Engineering Review
9/23/2019 7:58:02 AM
dsdrice
JedRice@epcinc.com
(719) 536-7877
EPC Planning & Community
Development Department

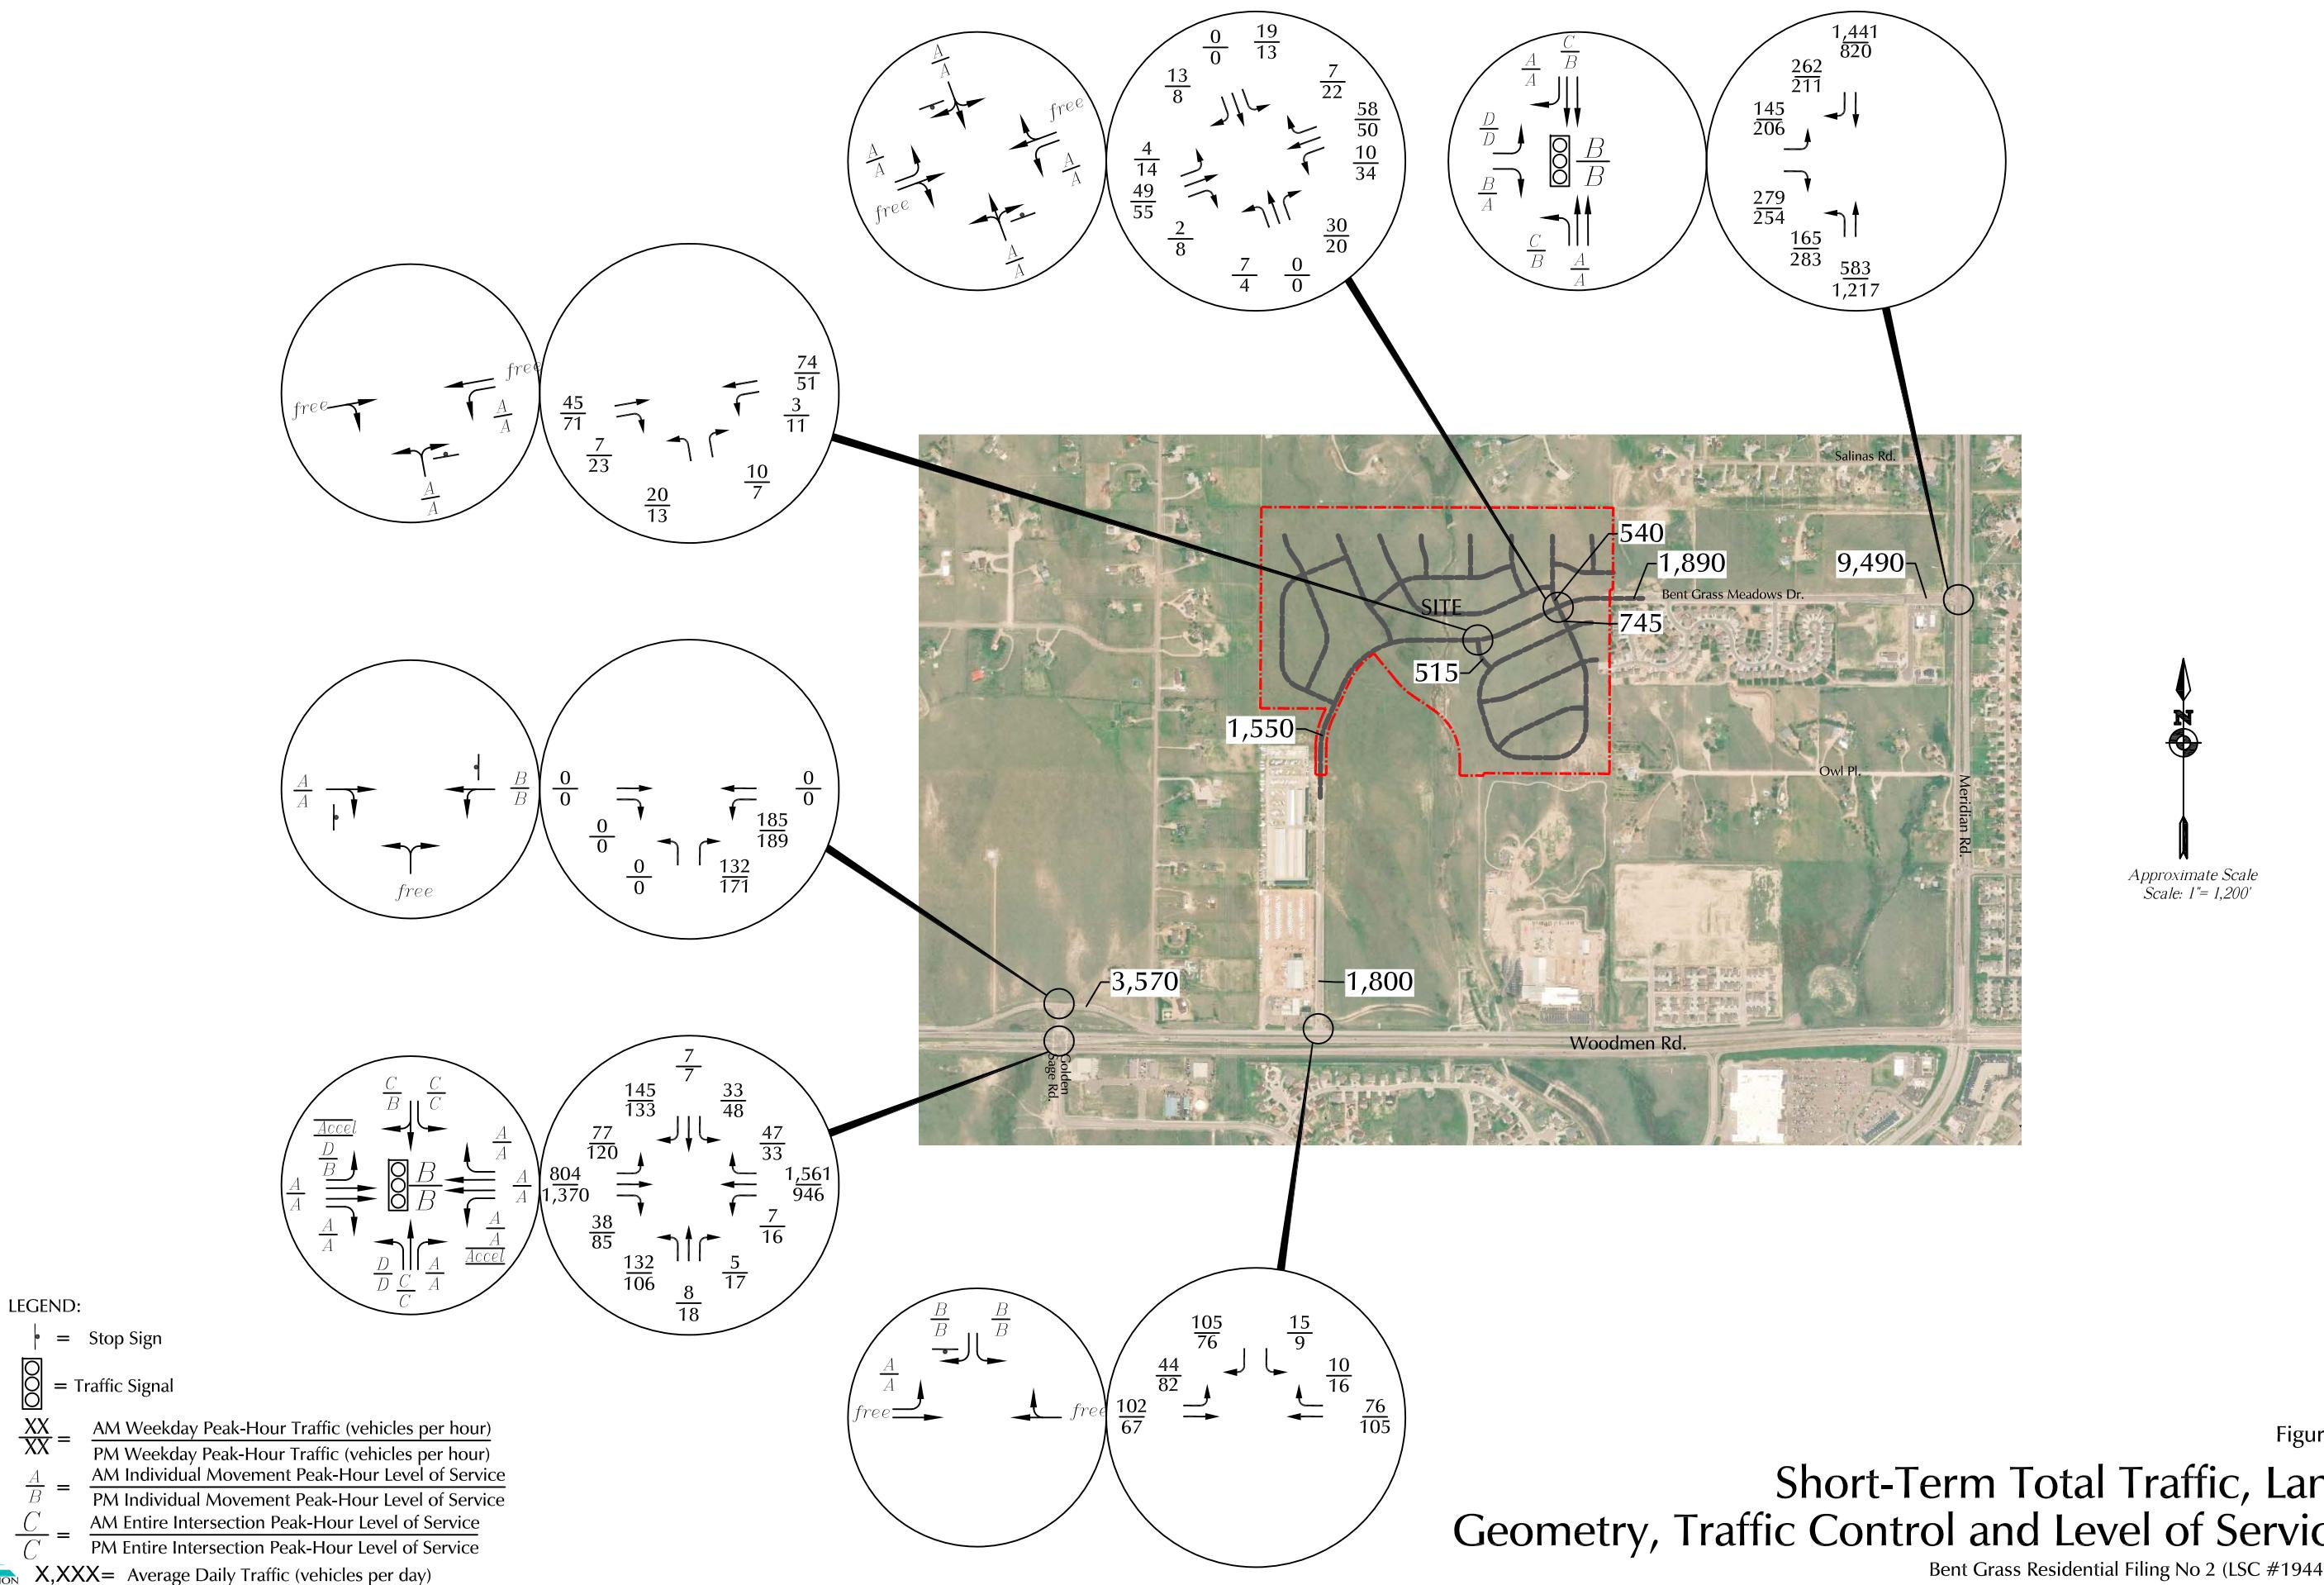
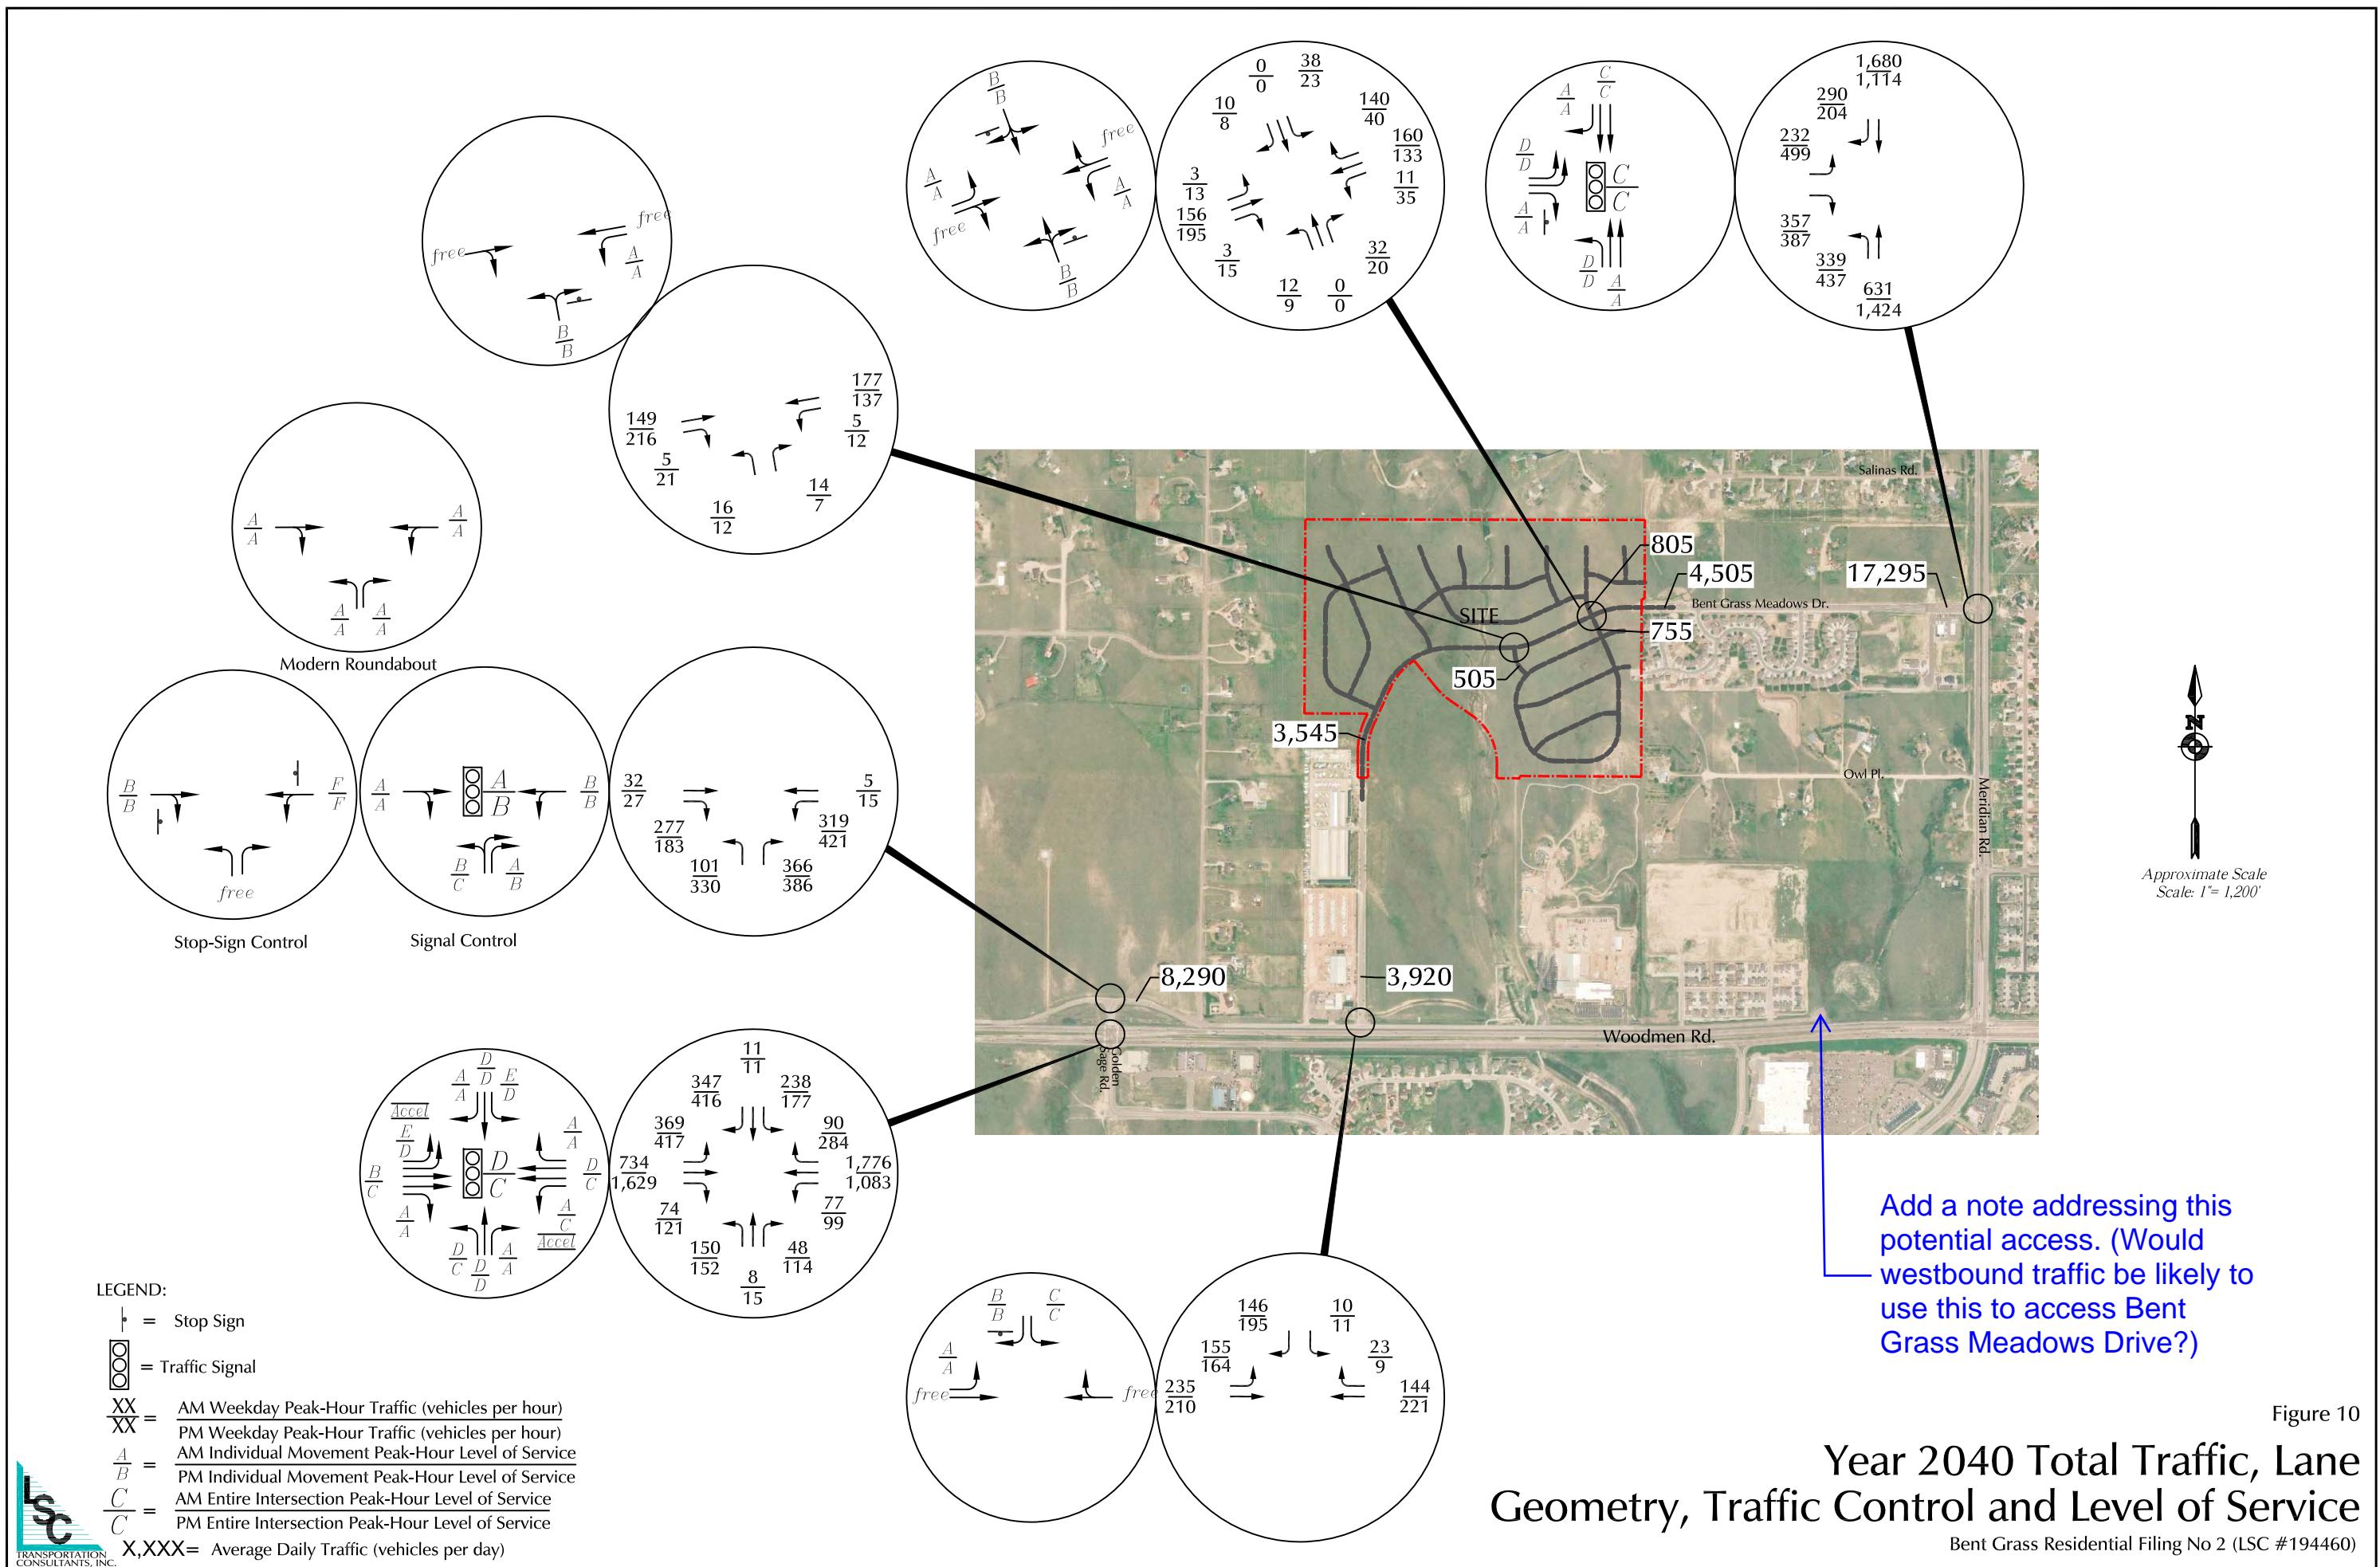
Why did these go down so much?
